From:
To: [DCAdmin](#)
Subject: Planning Application: 2020/91652
Date: 11 June 2021 16:50:03

Drawing Title
PROPOSED EXTN.

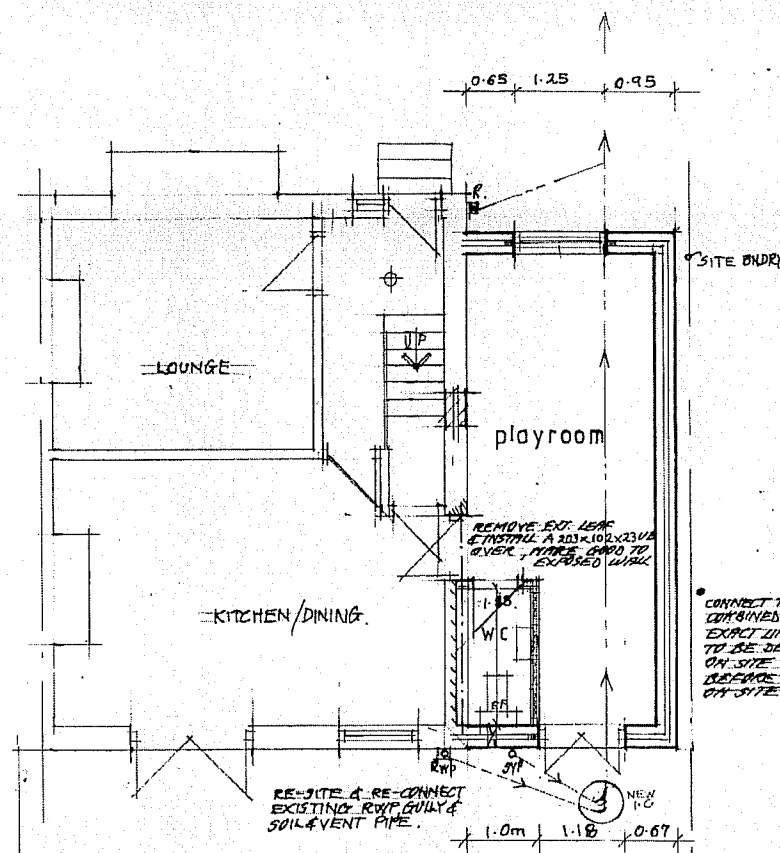
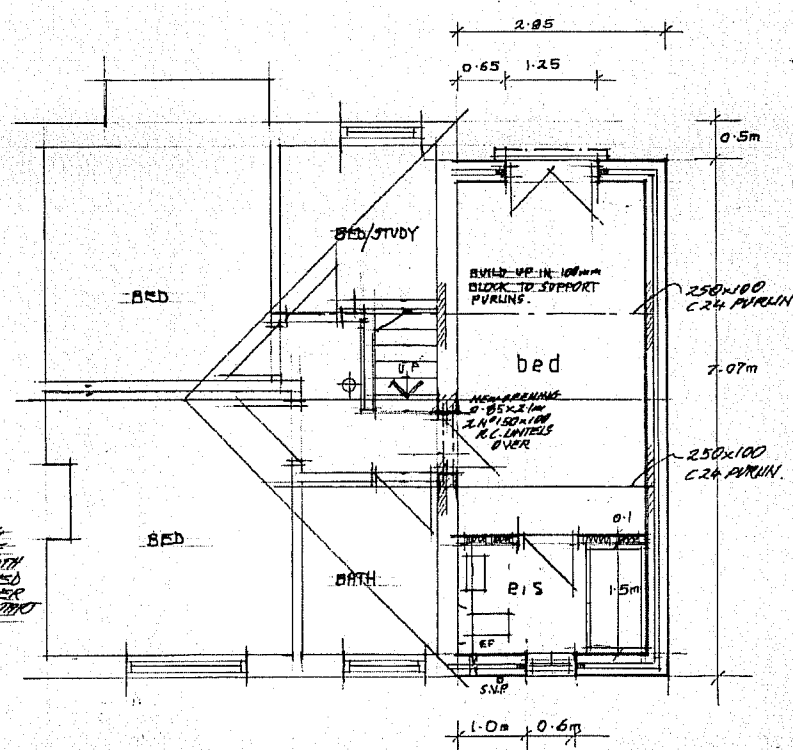
Please see attached photo, I would like some advice regarding the boundary wall. I feel this new wall is either too close or crossing the boundary to my house. Please can I have some advice regarding rules/guidance regarding boundary walls.

On the plans for this extension I cannot see how much gap is supposed to be left between boundary walls. This plans show a gap whereas this wall has been built right up to the boundary wall, as you can see from the picture they have cut into the existing boundary wall to lay the new bricks. I would really appreciate it if someone could contact me to discuss this.
